November 03, 2023

RE: Responses to Comments
Dutch Bros Coffee
1125 Snow Vista Boulevard Southwest, Albuquerque, New Mexico 87121
Our Job No. 23007

We have revised the plans and technical documents for the above-referenced project in accordance with your comment letter dated October 20, 2023. Enclosed are the following documents for your review and approval:

EROSION AND SEDIMENT CONTROL PLAN

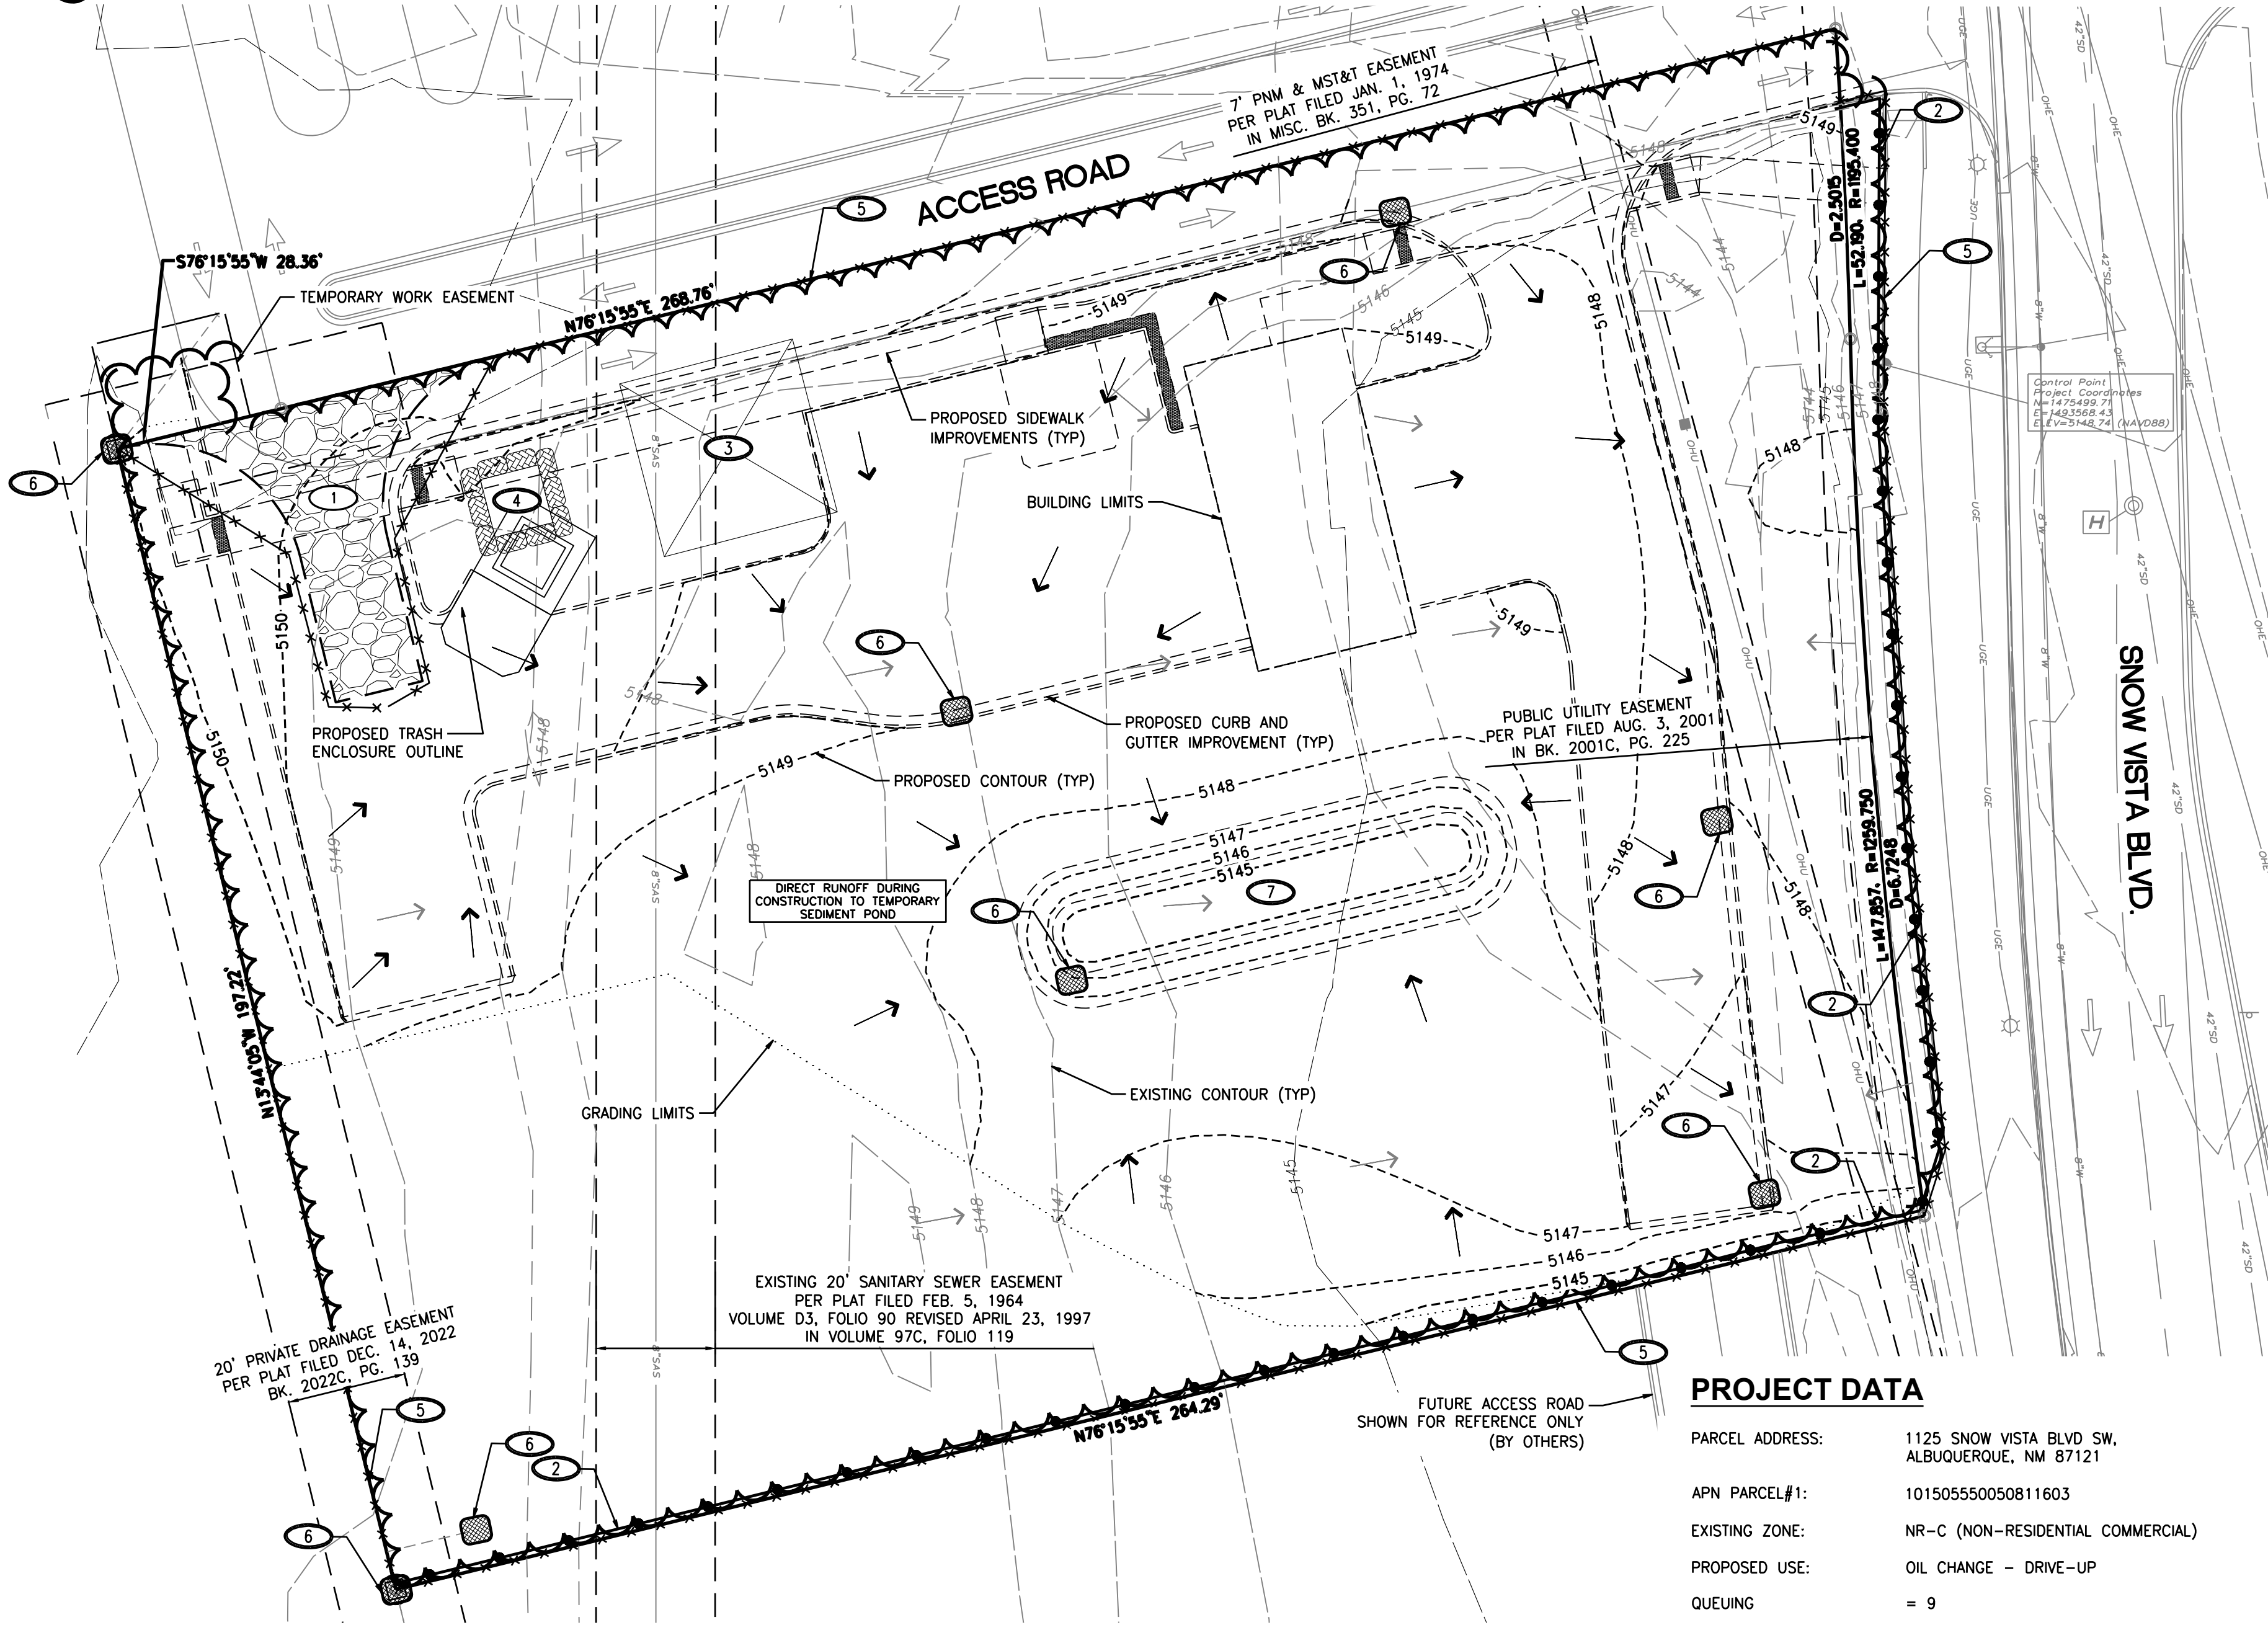
1. *The ESC Plan can't be approved until after Hydrology approves the G&D Plan for each specific purpose, Site Plan, Grading, Building Permit, and Work Order. Hydrology's comments on the Conceptual G&D haven't been addressed yet. The existing and proposed grades must be shown on the ESC Plan, and they must agree with the Grading Plan approved by Hydrology (CGP7.2.4.b.ii);*

2. *Identify locations of concentrated flow paths that enter and exit the disturbed areas. Identify locations where sheet flow enters and exits the disturbed area. Show on-site drainage patterns of stormwater before and after major grading activities. (CGP 7.2.4.f)*

3. *The building, sidewalk, asphalt, and dirt must be shown on the ESC Plan. These structures must be clearly identified in the SWPPP per CGP 7.2.4.b.vi.*

4. *Describe the nature and extent of construction activities (CGP 7.2.2.). Include the size of the property, and the size of the area of land disturbing activities onsite and offsite. Why is the project area less than the total lot area? Describe construction support activities and show any staging area on the ESC Plan.*

5. *Note on the ESC "This site is part of a Common Plan of Development or Sale that exceeds 5 acres. Every part of this Common Plan of Development or Sale must have coverage under the CGP. Waivers aren't allowed."*

Response: The existing and proposed grades are shown on the ESC Plan. The grades agree with the Grading Plan. We are currently coordinating Grading and Drainage Plan approval. A copy of the approval will be provided once received.

Response: The plans are showing on-site drainage patterns before and after major grading activities.

Response: The building, sidewalk, asphalt, and dirt have been added on the ESC Plan.

Response: The size of the property and size of the area of land disturbing activities have been added. The project area has been revised to reflect the whole lot; however, the grading limits will be less than the parcel area. The plan has been revised to provide landscaping on all non-impervious surfaces. The staging area is shown on the ESC Plan.

Response: The note has been added.
